I am making the objection about the Exhibition of State Significant Development Application – Response to Submissions and Revised Proposal of Lindfield Learning Village (LLV) Phases 2 and 3 Application No. SSD-8114.

Landscape Blow Up Plan 8
Bus turnaround extended driveway zone

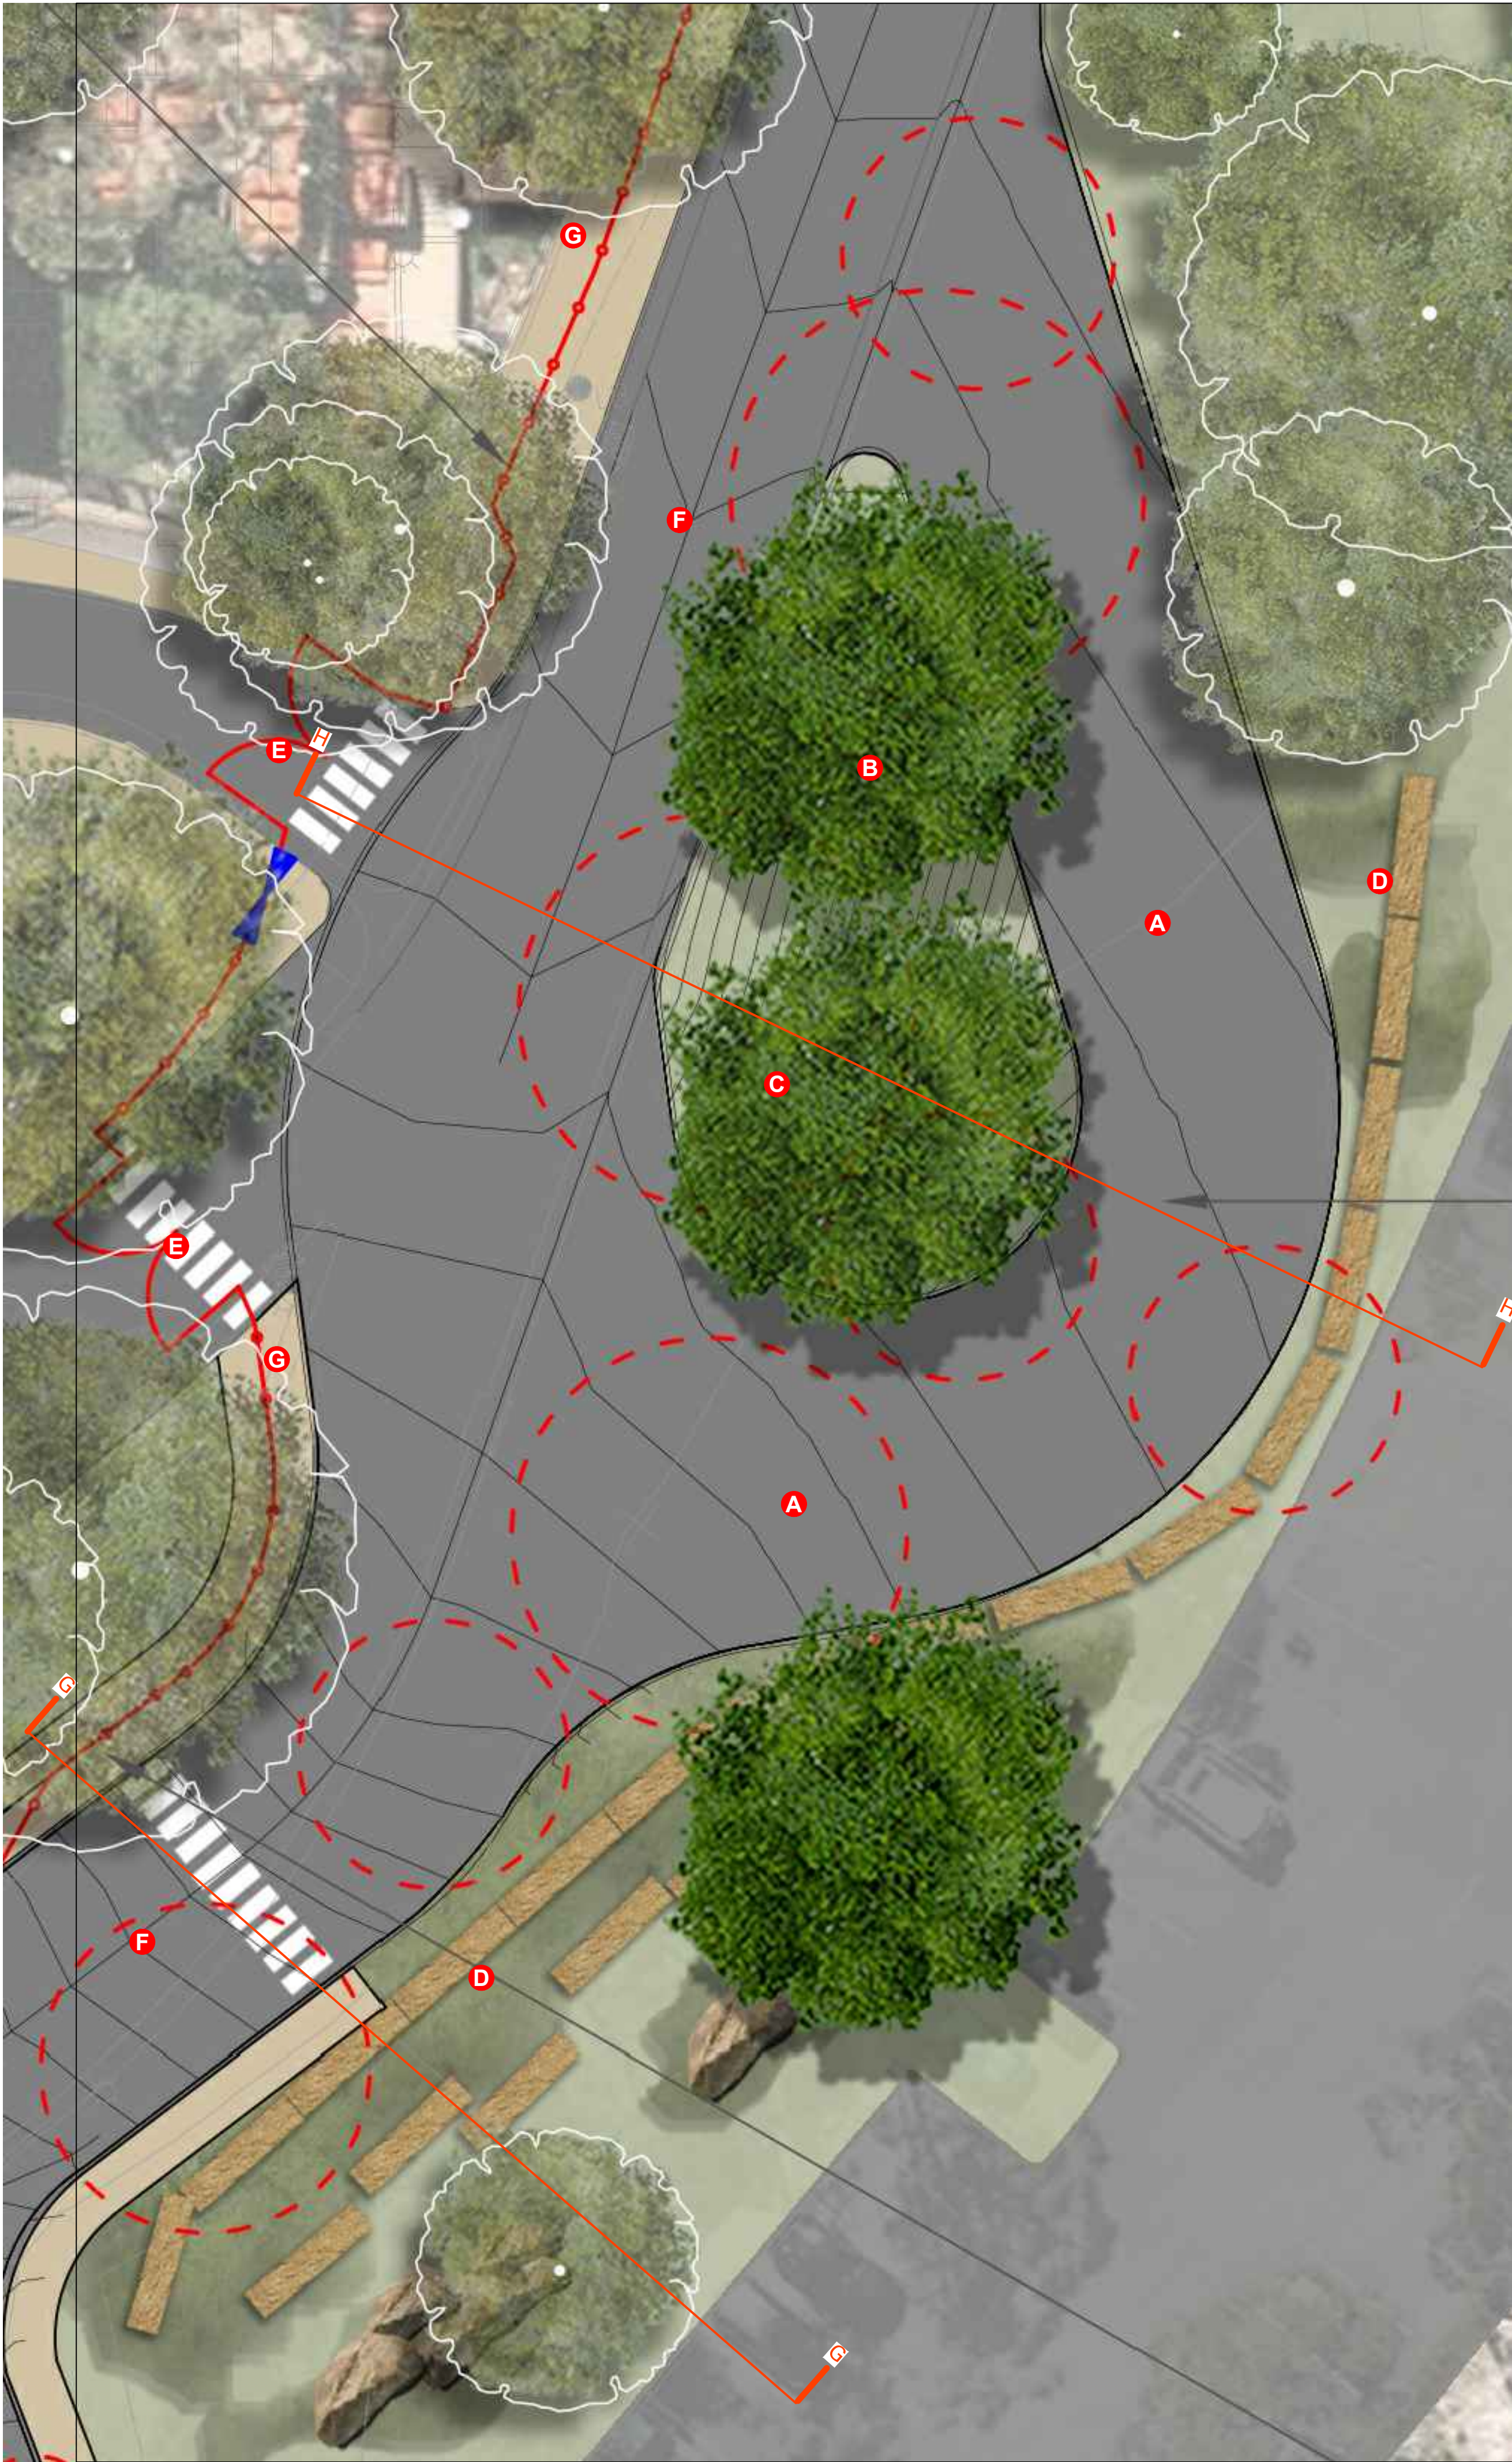
I would like to express my greatest concern in relation to the number of students (1,050 students in Phase 2) transport travel down to Dunstan Grove and then circulate around the rear of the School.

Dunstan Grove is located at the end of the Eton Road. The road is an extremely narrow and curved road and was only built for very limited access. The proposed loop road to cater for the projected 2,000 students is completely unsuitable, impractical and risk-prone to the safety of the surrounding communities within Crimson Hill.

The proposal ignores the safety of Dunstan Grove residents and visitors and also the students and staff at LLV. It will be extremely dangerous for Dunstan Grove residents and visitors in the morning and in the afternoon exiting and entering to the resident carpark experiencing the heavy number of cars and buses sharing the same narrow and curved Eton Road.
